**Jean Fraser - Re: 133 York Street/Harborview Flats**

**From:** "McGee, Martin" <Martin.McGee@FMR.COM>  
**To:** "'JF@portlandmaine.gov'" <JF@portlandmaine.gov>  
**CC:** "'mcgeekm@verizon.net'" <mcgeekm@verizon.net>  
**Date:** 10/11/2013 10:53 AM  
**Subject:** Concerns and Questions regarding 133 York Street

**From:** Erin Foley <efoley19@aol.com>  
**To:** Jean Fraser <JF@portlandmaine.gov>  
**Date:** 10/22/2013 4:47 PM  
**Subject:** 133 York St

**From:** Hallie Gilman <hallie.gilman@gmail.com>  
**To:** <bab@portlandmaine.gov>, <JF@portlandmaine.gov>  
**CC:** Ned Flint <info@nedflint.com>, Dave Marshall <marshalldistrict2@gmail.com>, Hallie Gilman <hallie.gilman@gmail.com>  
**Date:** 11/6/2013 5:36 PM  
**Subject:** Comments re 133 York Street

LANDSCAPE NOTES

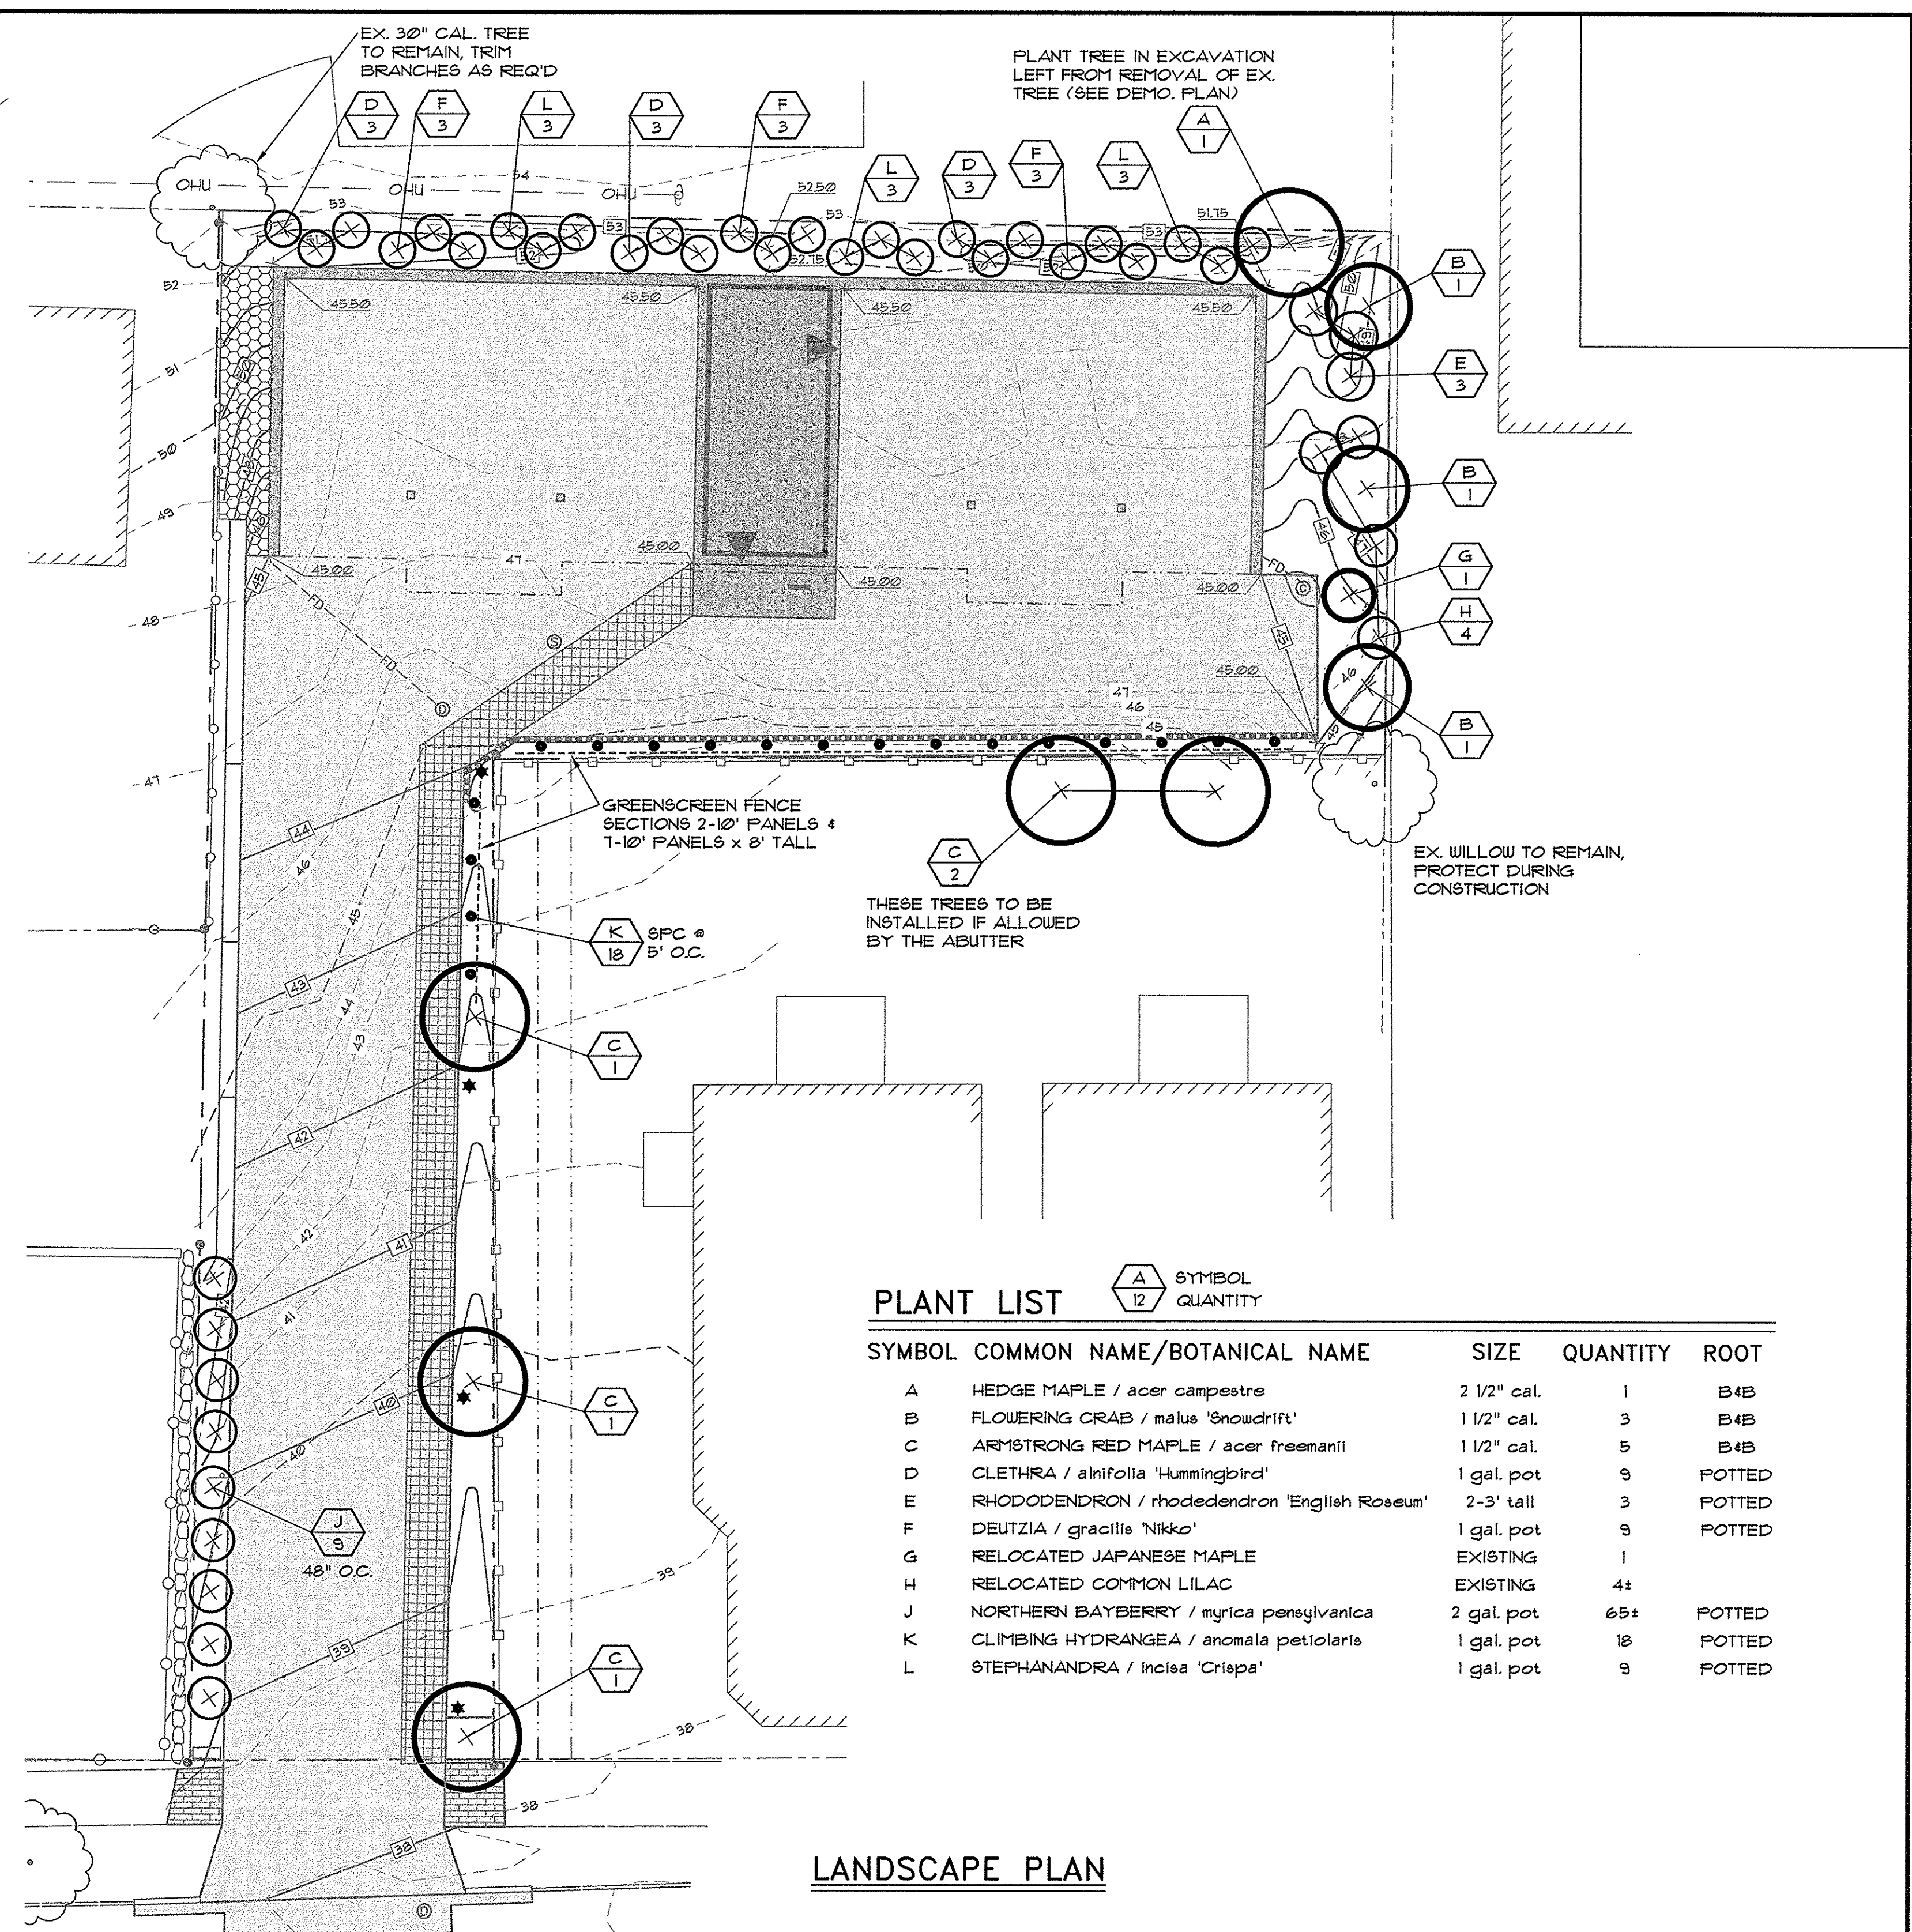
Below is an updated image with the green wall highlighted in yellow. The areas noted in blue (below) are our primary concern; hence the placement of the green wall is puzzling to me. Perhaps our concerns were not clearly stated.

AS the plan sits, the headlights from cars that are backed into your parking area will shine directly into the first floor condos (in blue) at the Flats. This unscreened area is noted with the red arrows above. The green wall and trees (as they are currently proposed) will not adequately address our concerns.

- 1) In your present design, is the green wall only planned for the section that is highlighted in yellow in the image below (the corner area)?
- 2) If YES, what provisions (beyond the trees you cited) have you made for affording the Flats screening and privacy from the parking area?

The suggestions in your email sound like you are moving in the right direction. When you say, "the corner of the fence in your backyard", can you give me a better sense of what area would / would not be screened by the green wall? As the plan sits, the headlights from cars that are backed into your parking area will shine directly into the first floor condos at the Flats. I would be very interested in additional details as to the placement and length of the green wall.

Do you have any plans for providing privacy or screening to the adjacent Townhomes building (the modern building next to your property)? There has been discussion about planting one or more small trees, but this will not afford the privacy that the present tree provides (which apparently cannot be saved with your current design). I will be interested in hearing your plans for that side of the property and will pass along your ideas to the Townhomes residents.

I see your concerns about the headlights as illustrated by the red arrows. I have asked the engineer to update the site plan to show a "green wall" to continue all the way across the fence. I will keep you updated on the façade.

1) The green wall goes beyond what you have highlighted, it is represented by the dashed line. It goes to about where the front door is located and further down the driveway.

2) The additional provision is in fact the two trees on the plan – this was suggested by the city arborist. We have added the trees and green wall to help with the privacy concerns.

3) The extra privacy for the town homes is provided with the additional 12 trees and shrubs as detailed on the plan.

I attached an updated site plan that illustrates the proposed trees and "green wall" addressing the planning board and abutters concerns. The plan identifies the location, species, and size of the plantings. I spoke with the architect this afternoon, he is working on the façade design. I will forward you the "re-worked" design as soon as it is available.
